re: Geotechnical Recommendations - Service Pipe Crossing
Proposed Residential Development
2710 Draper Avenue - Ottawa

date: August 12, 2019

file: PG1630-MEMO.26

Stone Strong Retaining Wall Design, Proposed Retaining Wall

CROSS SECTION A-A

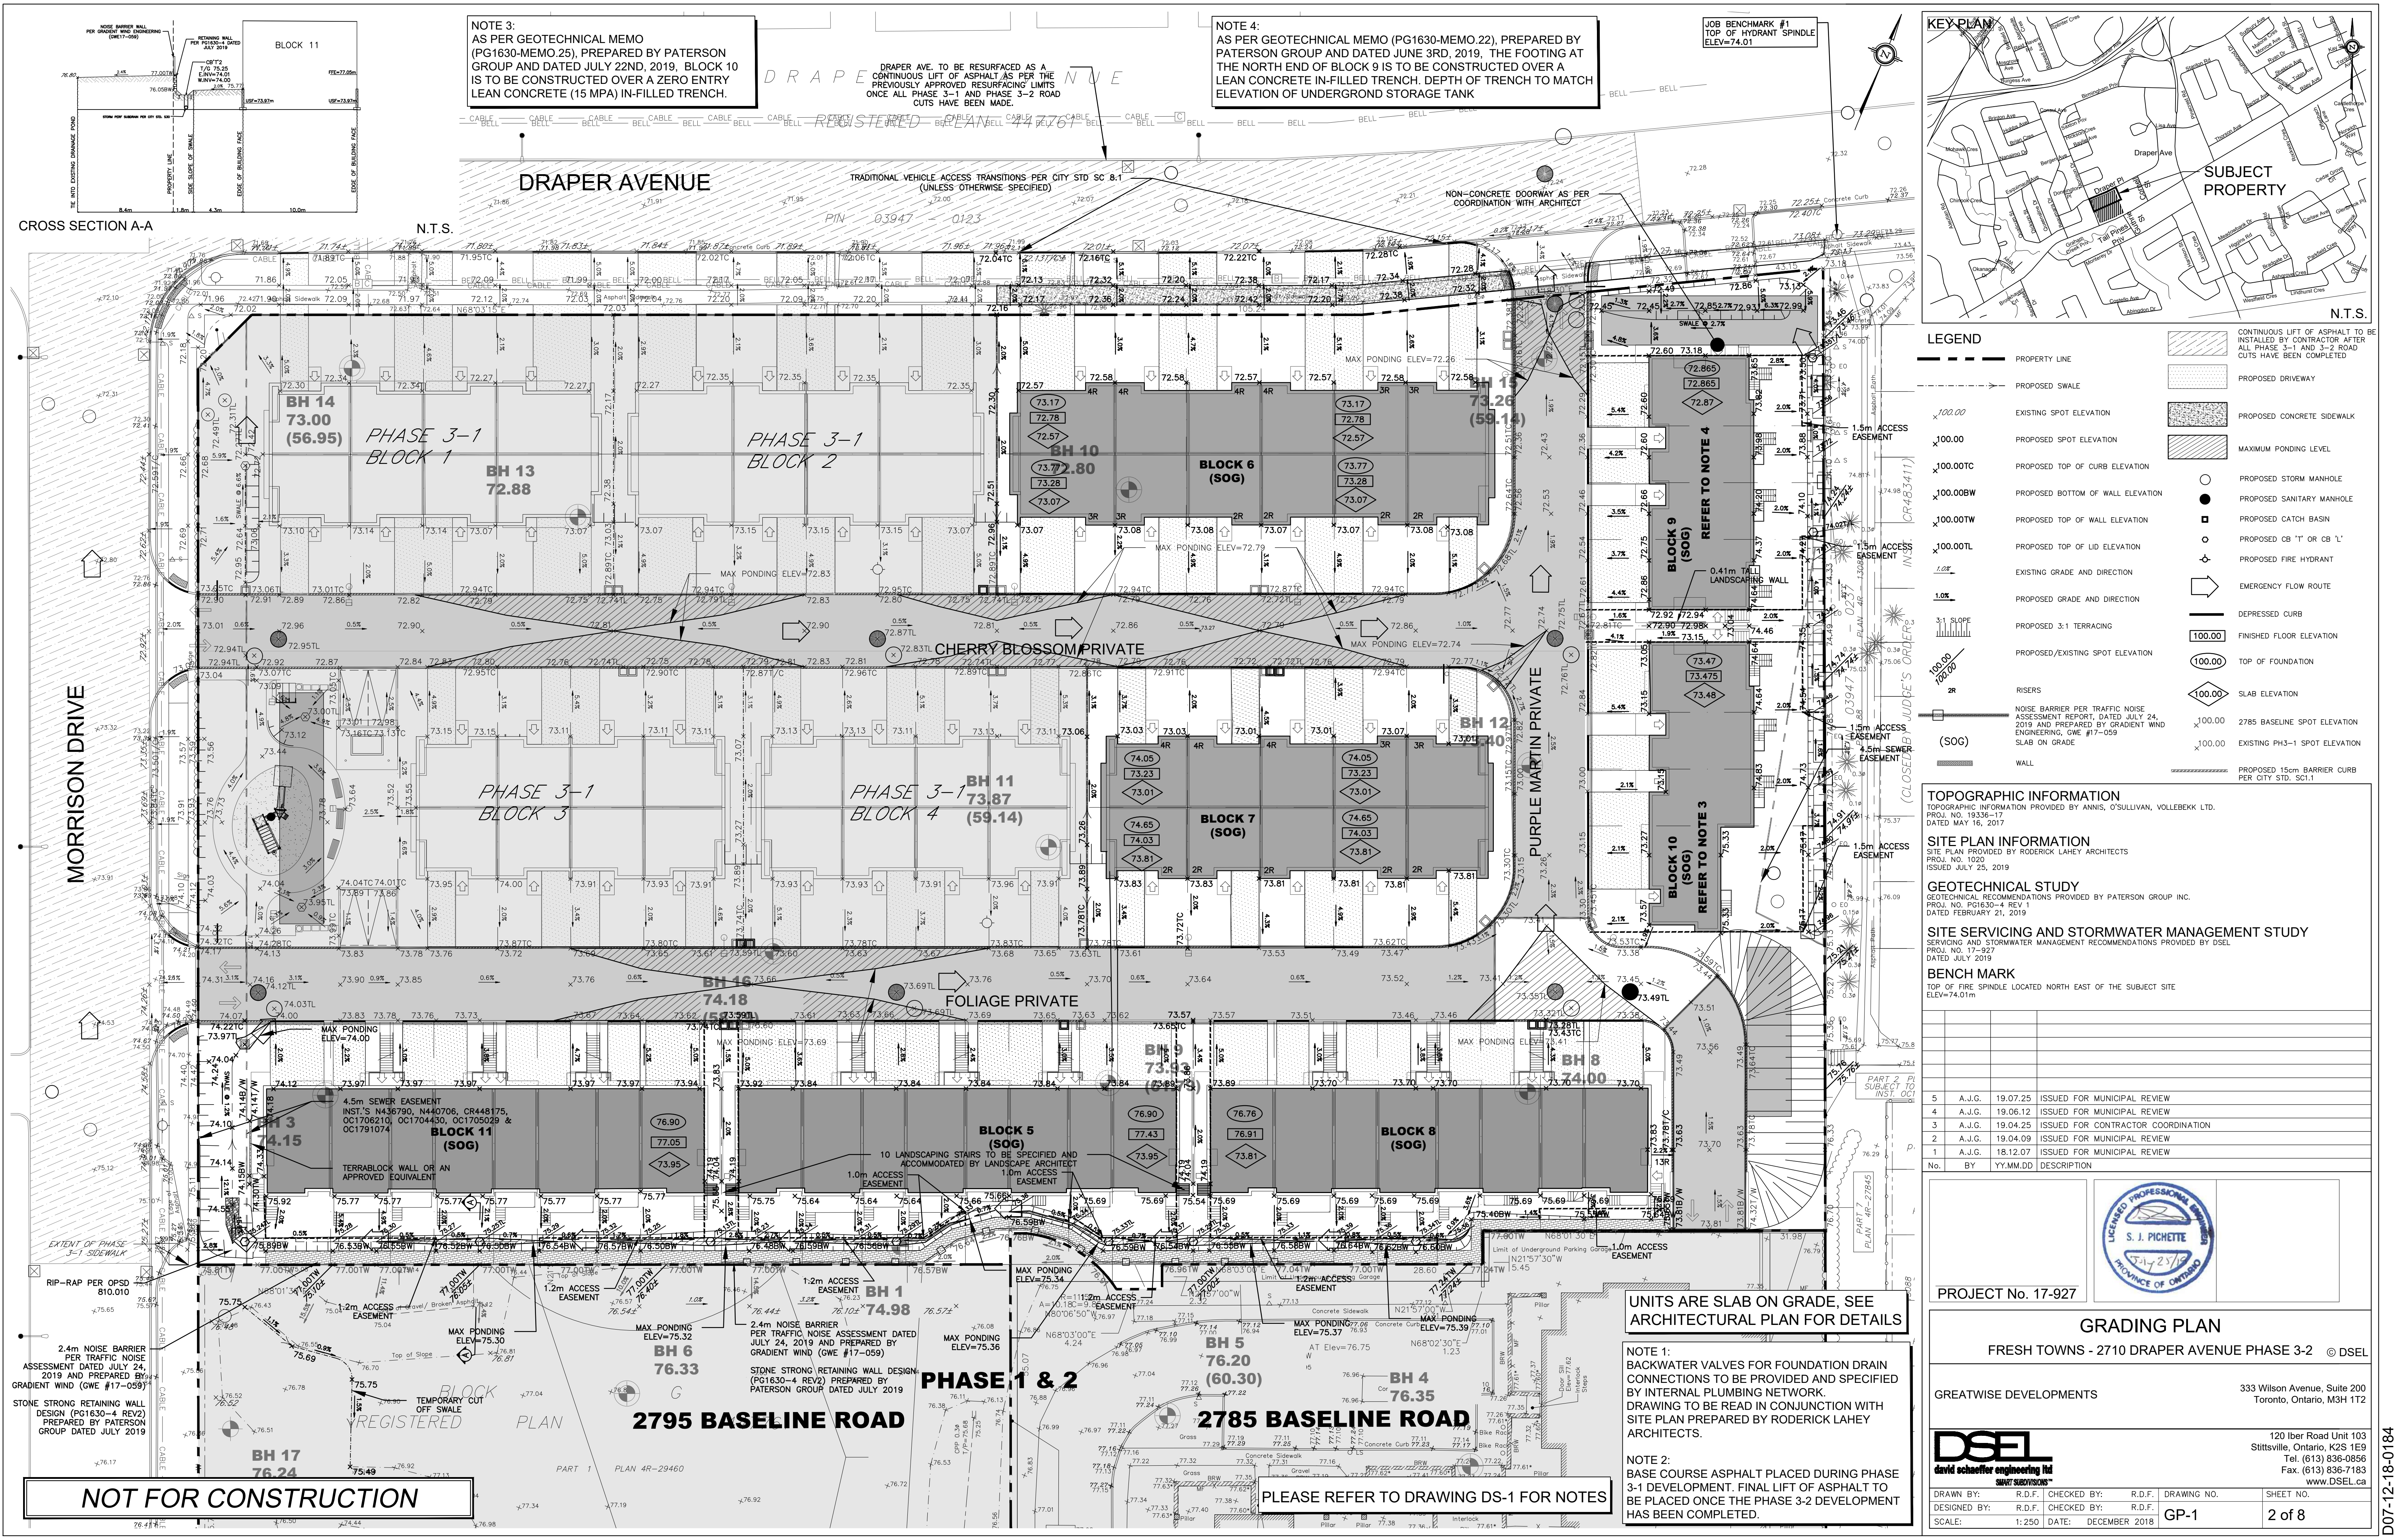
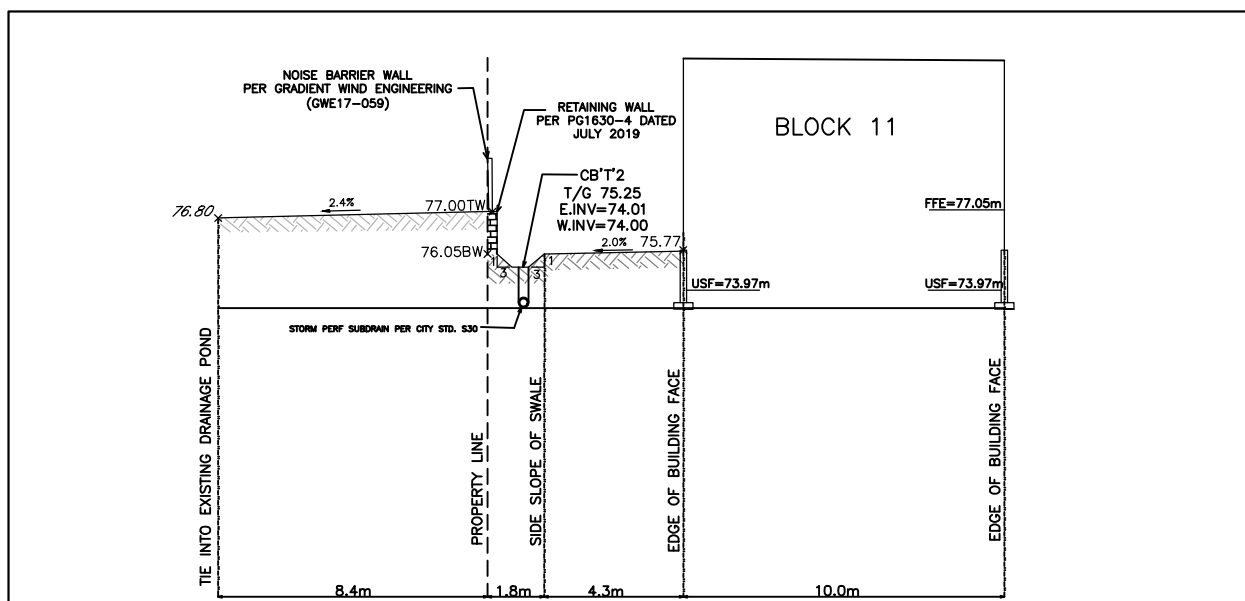
Based on our review of the above noted plans and discussions with the design team, it is understood that a service pipe is proposed to extend below the proposed retaining walls and future turning circle. To ensure a long service life for the subject service pipes and to avoid undermining the retaining walls during excavation for any required maintenance, the pipe is recommended to be encased with a slightly larger steel or higher grade PVC casing at each retaining wall crossing. This methodology is considered acceptable from a geotechnical perspective provided the following is implemented:

- ☐ All backfill material to be used between each retaining wall and the service running below, should consist of engineered fill such as OPSS Granular A or Granular B Type II or an approved alternative. The granular Material should be completed to a minimum 98% of the material's SPMDD.
- ☐ The steel encasement should be slightly larger than the corresponding service line and should extend a minimum of 1 m beyond the lateral support zone of the retaining wall (1.5H:1V). Based on the proposed grading plan the steel sleeve should **extend 2.2 m** from the face and back of the walls base block. It should be noted that the lateral support zone of the wall will is measured from the toe of the bedding layer.

- ❑ It is recommended that the steel casing be plugged with lean concrete on both ends. The extent of the concrete should be a minimum of 600 mm beyond the edge of the steel pipe. This will protect the encased pipe during backfilling operations.
- ❑ All field work regarding encasing the subject pipes should be inspected and approved by Paterson at the time of construction.
